Rezoning Transportation Analysis

Petition Number: #2021-120

Revision Log:

Date	Description
09-28-2022	First Review (AO)

Revised Site Plan 10.17.22

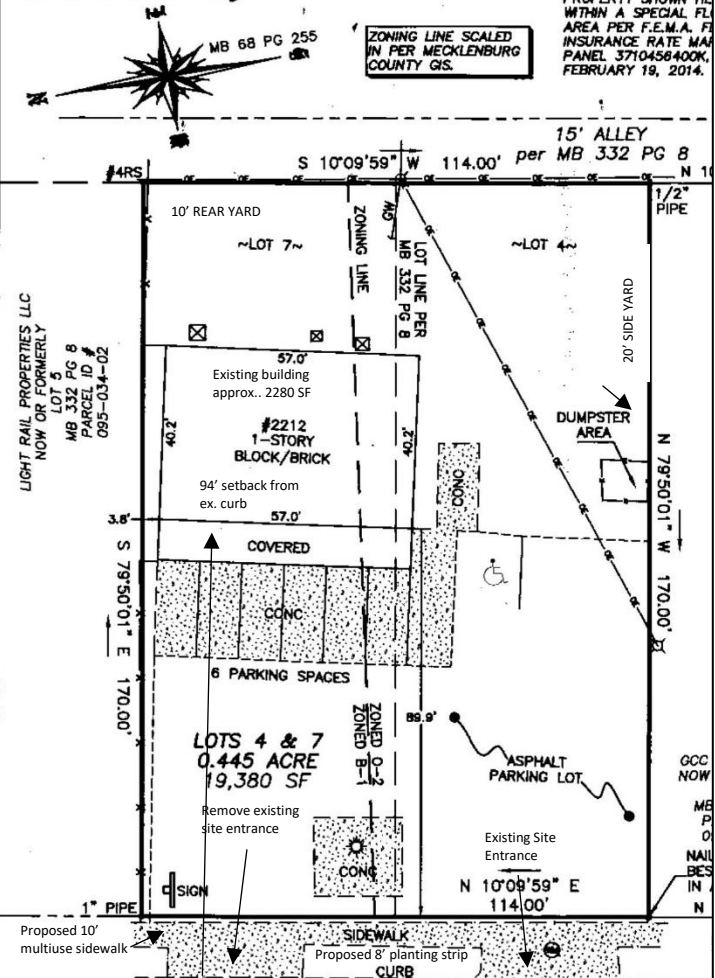
1. **Curblin**~~e~~: The proposed zoning district has a setback measured from back of the existing or proposed future curblin~~e~~.
 - a. **The Plaza**: Maintain existing curblin~~e~~.

Label and dimension the curb and gutter from the centerline for each road on the site plan.

3. Revise site plan and conditional note(s) to commit to dedicate minimum 50 feet of right-of-way from the road centerline of The Plaza if it does not currently exist. The site plan shall label and dimension the right-of-way from the road centerline.
4. Revise site plan and conditional note(s) to commit to construct an 8-foot planting strip, and 12-foot multi-use path on The Plaza. The site plan shall label and dimension both items from the back of curb and gutter.
5. Revise site plan and conditional note(s) to commit to removing existing bike ramp and green pavement markings just north of site. The site plan shall label and dimension both items from the back of curb and gutter.
6. Revise site plan and conditional note(s) to commit to consolidating from two access points to one.

7. Revise site plan and conditional note(s) to commit to remarking pavement markings and building a bike ramp near south property line to transition bicyclists from separated bike lanes to multi-use path.
